REQUEST

Current Zoning: RE-1 (research), and R-4 (single family residential)
Proposed Zoning: RE-3(CD) (research, conditional)

Approximately 19.79 acres located on the east side of Legranger Road and west side of Interstate 85, south of West Mallard Creek Church Road.

The petition proposes a residential community of up to 184 multi-family residential dwelling units together with accessory uses allowed in the RE-3 district.

SHEET NUMBER  
**RZ-01**

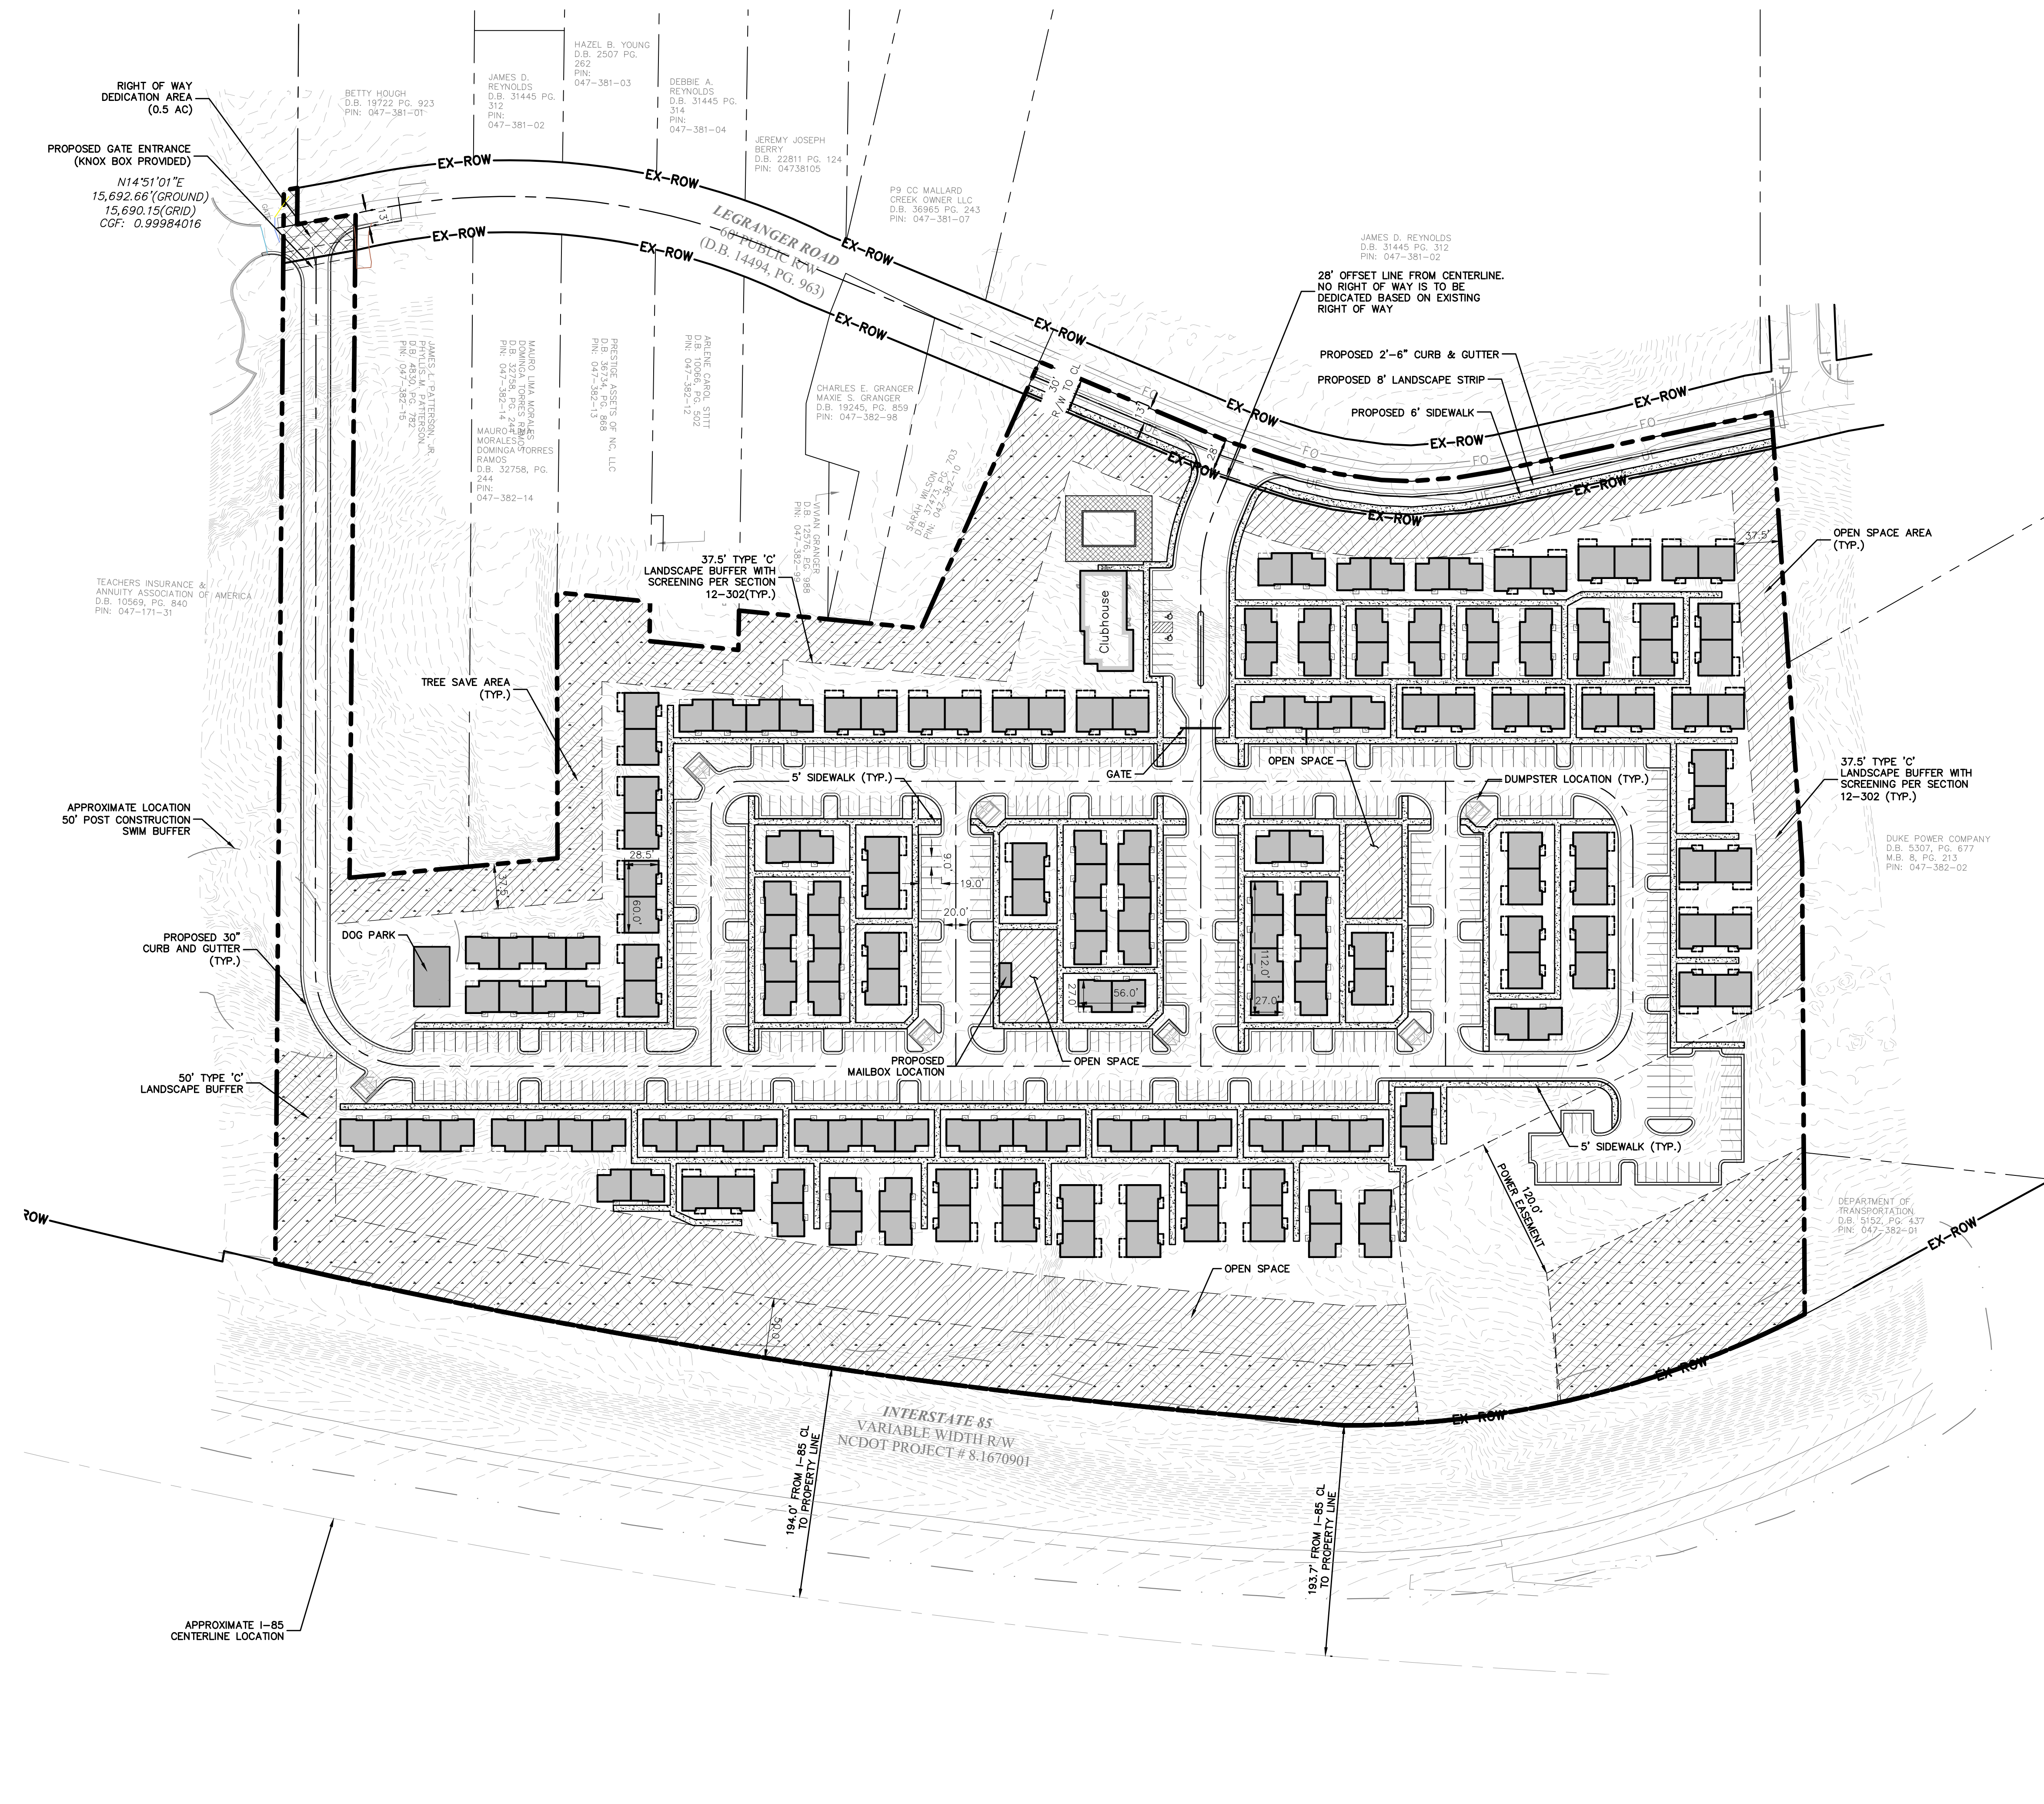
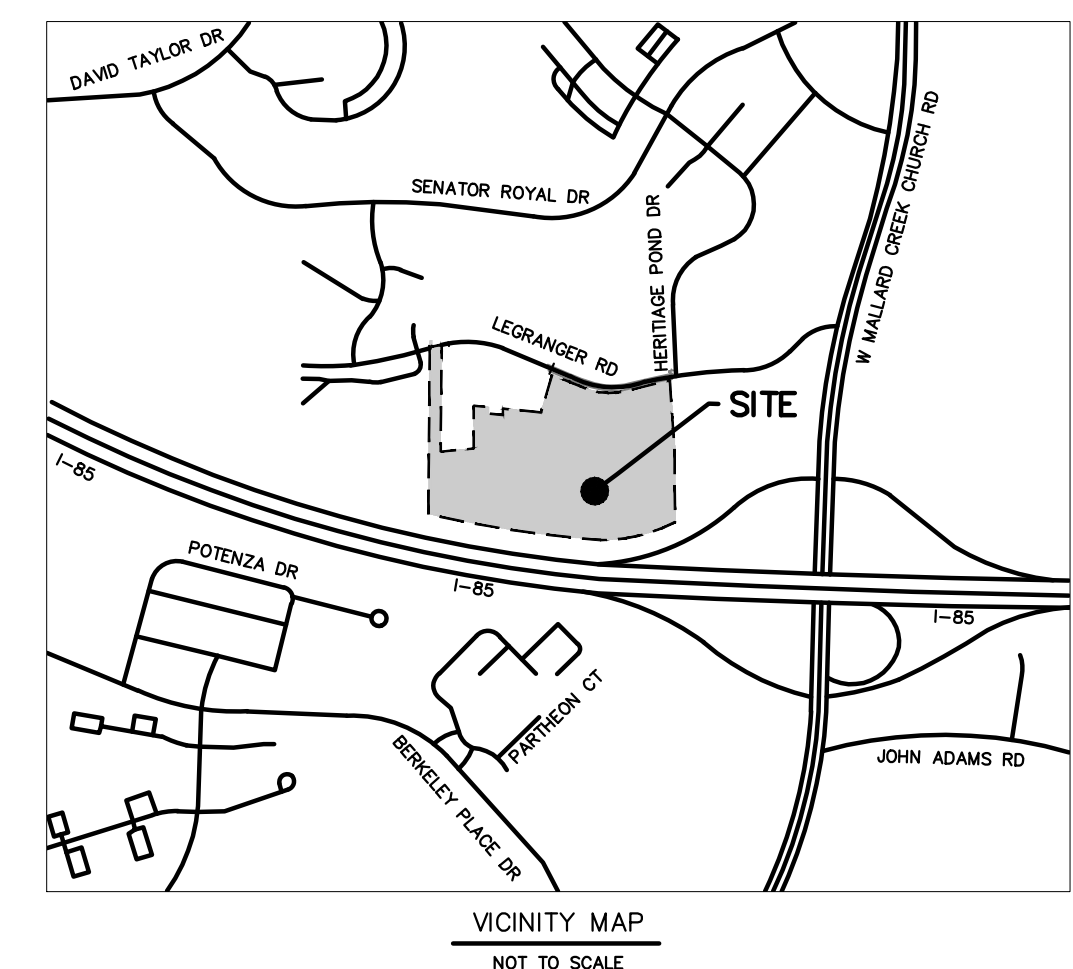
1. Add a conditional note specifying "the Petitioner shall dedicate and convey in fee simple all rights-of-way to the City before the site's first building certificate of occupancy is issued. CDOT requests rights-of-way set at 2' behind back of sidewalk where feasible."
